BOLTON-BY-BOWLAND, GISBURN FOREST & SAWLEY PARISH COUNCIL

PLANNING APPLICATION NO: *0804/5*
RELATING TO *RODHILL LIDGE, BOLTON-BY-BOWLAND*

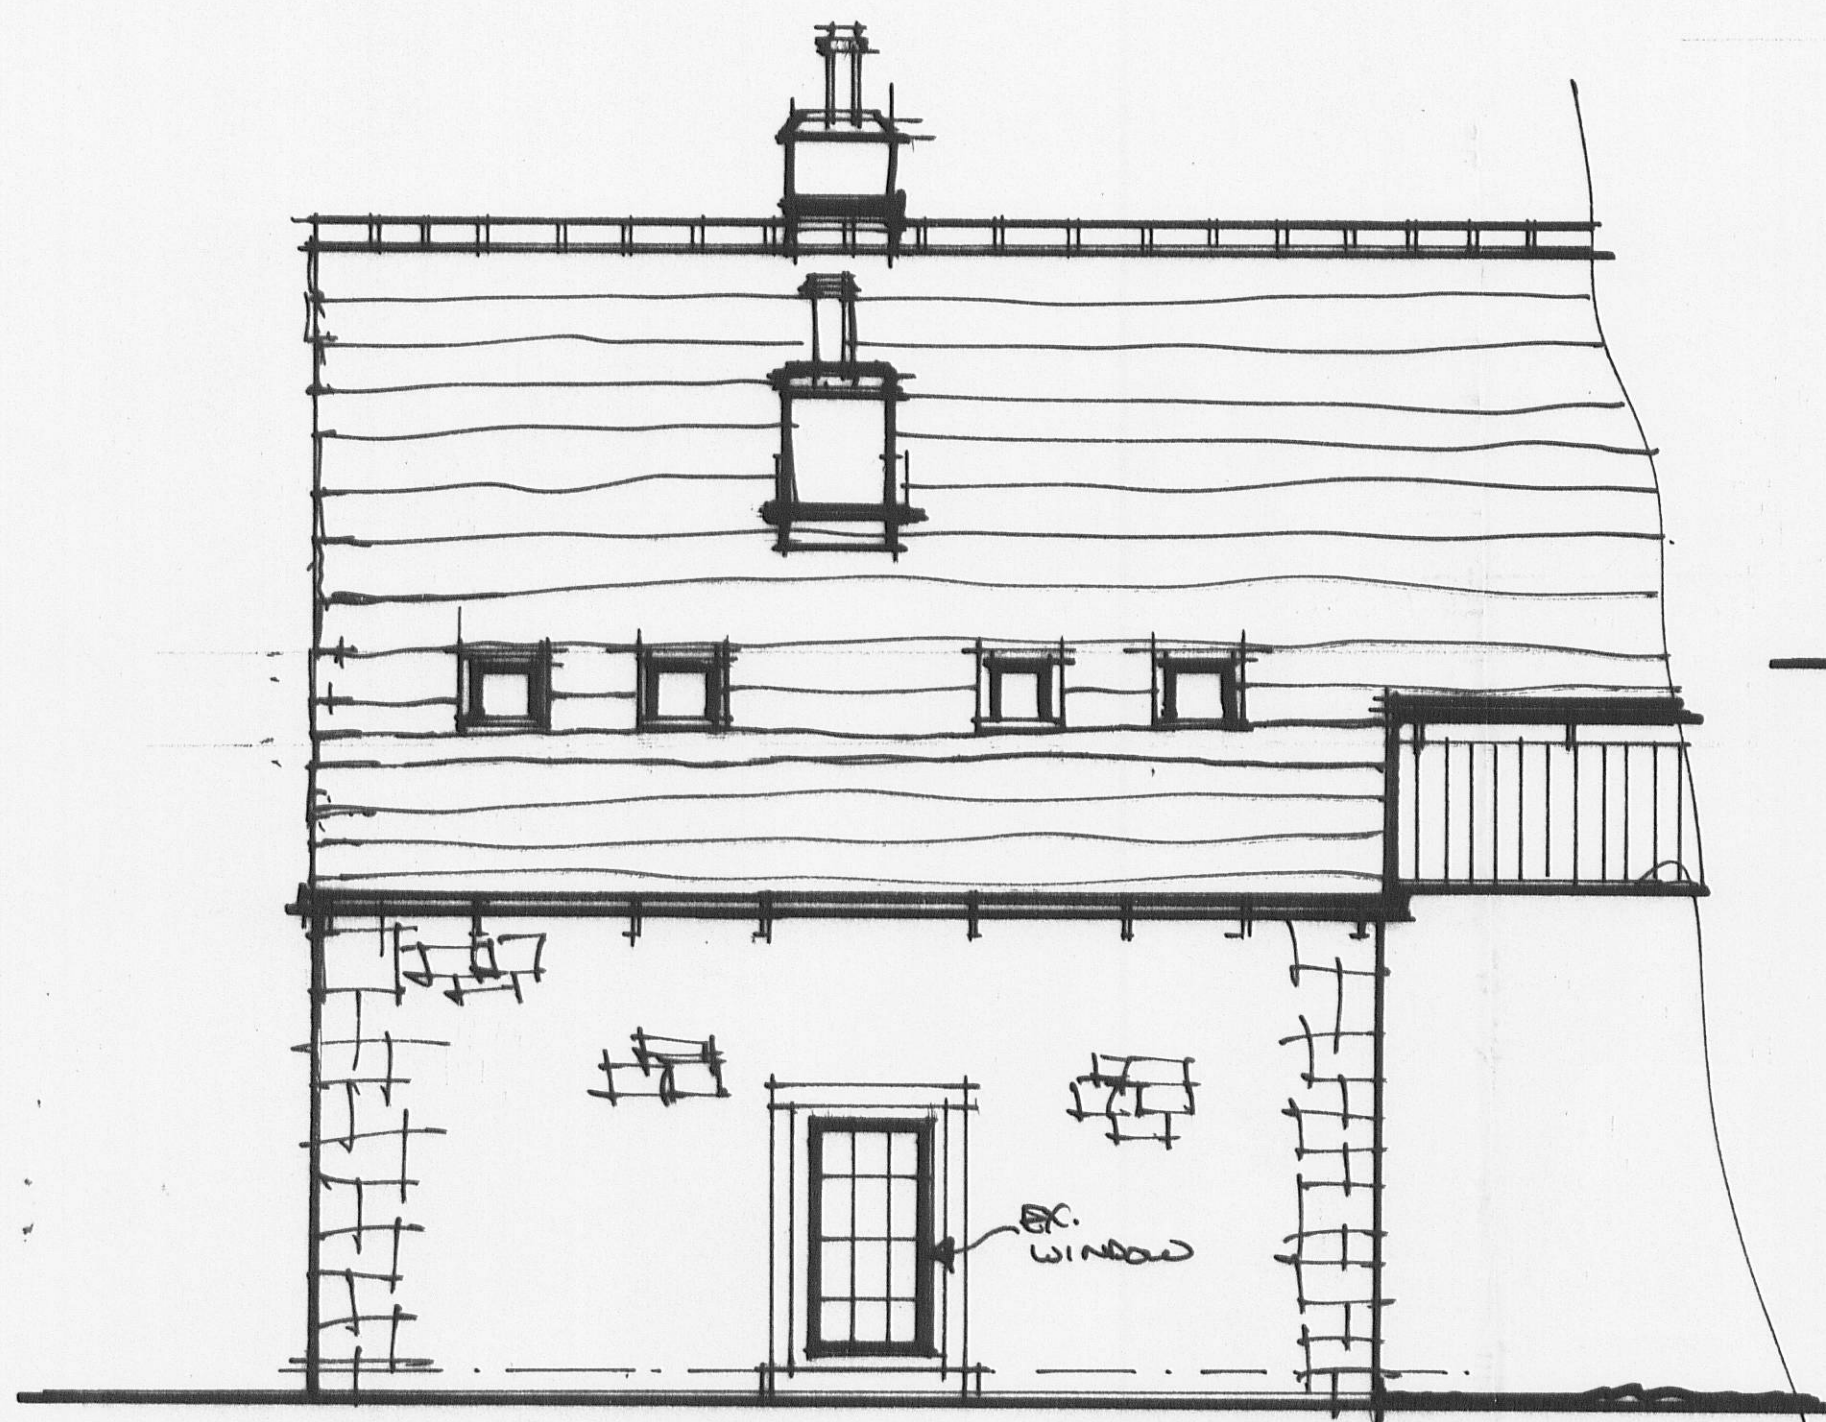
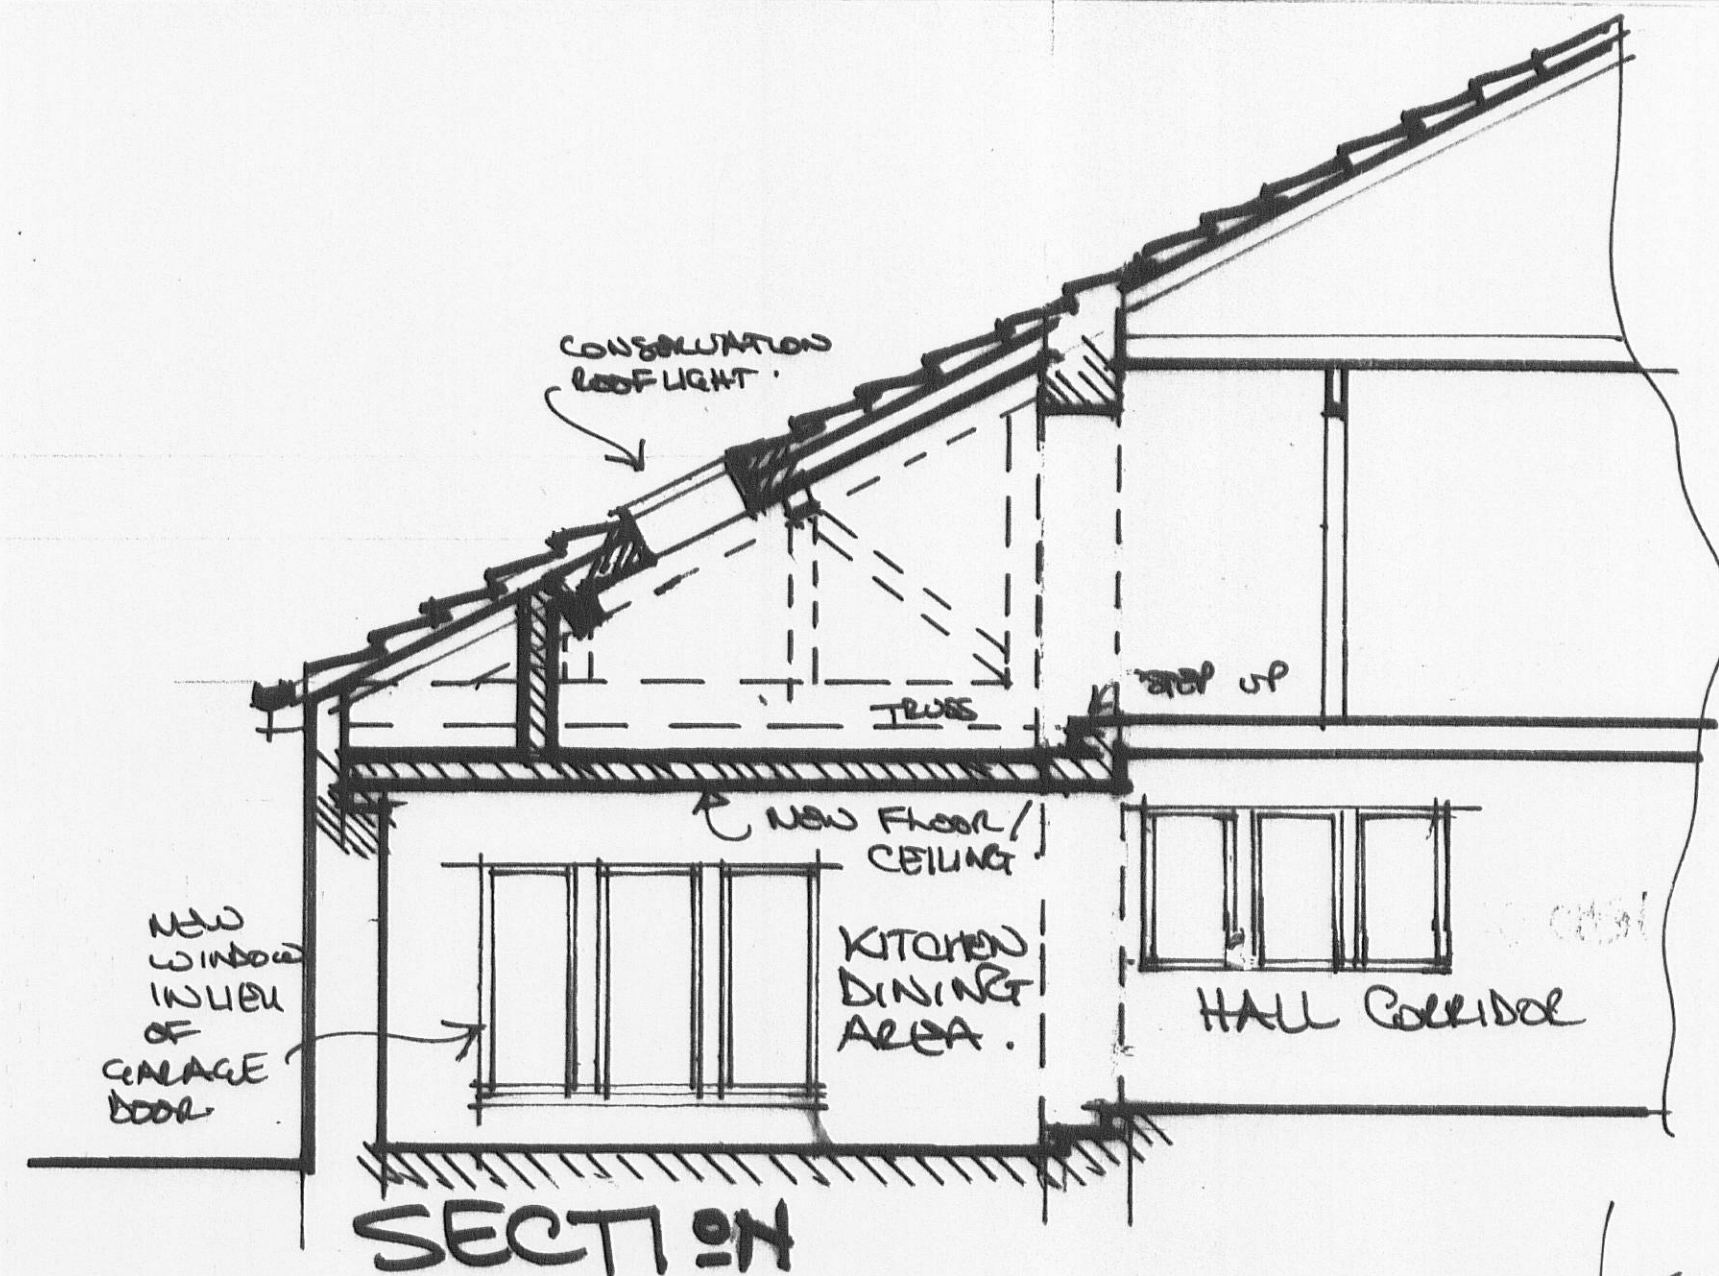
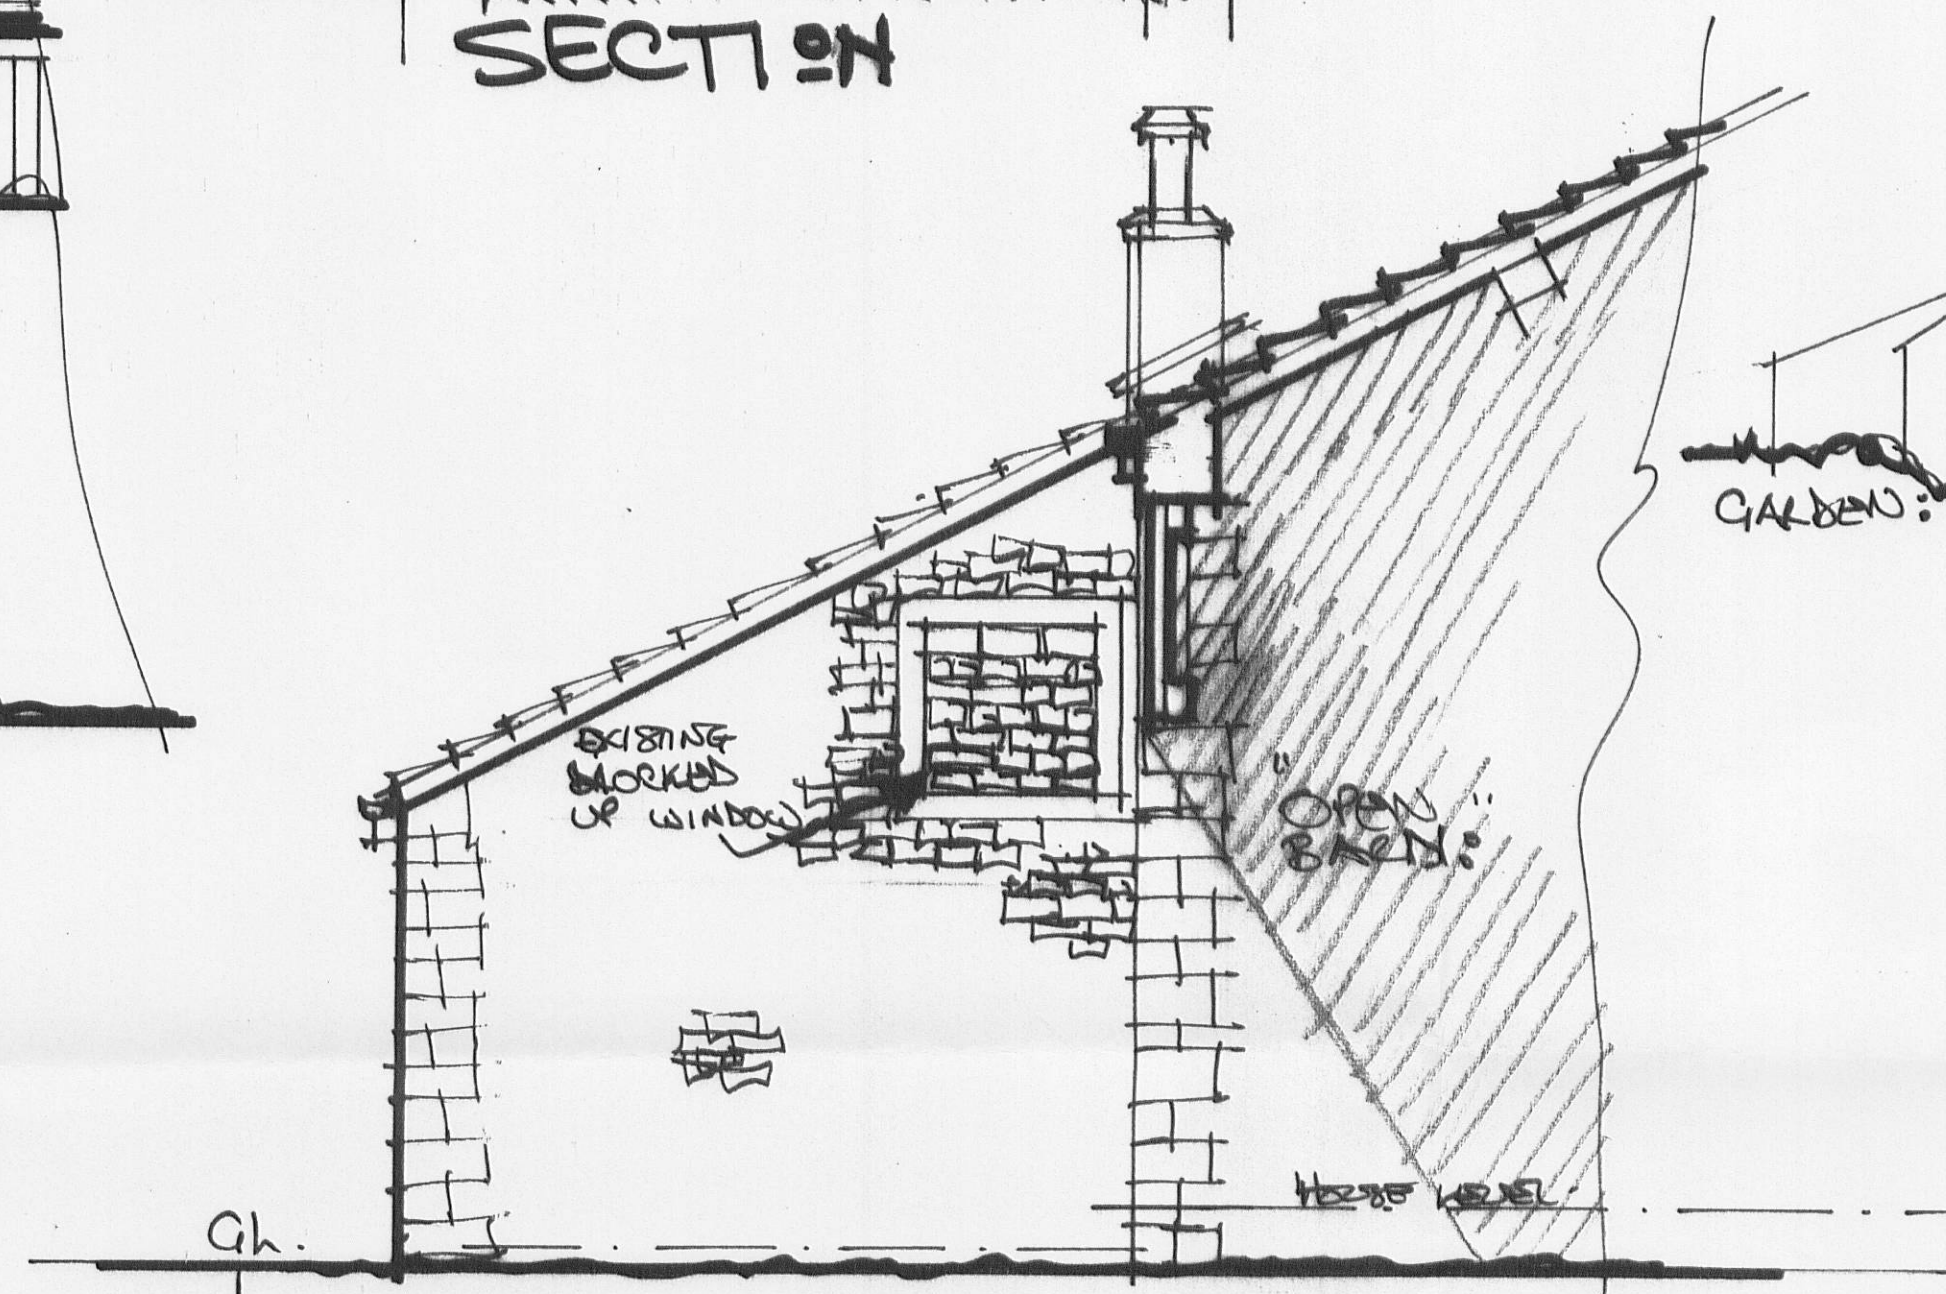
*QUERY THE NEED FOR 4 ROOF
LIGHTS ABOVE LOBBY ROOM*
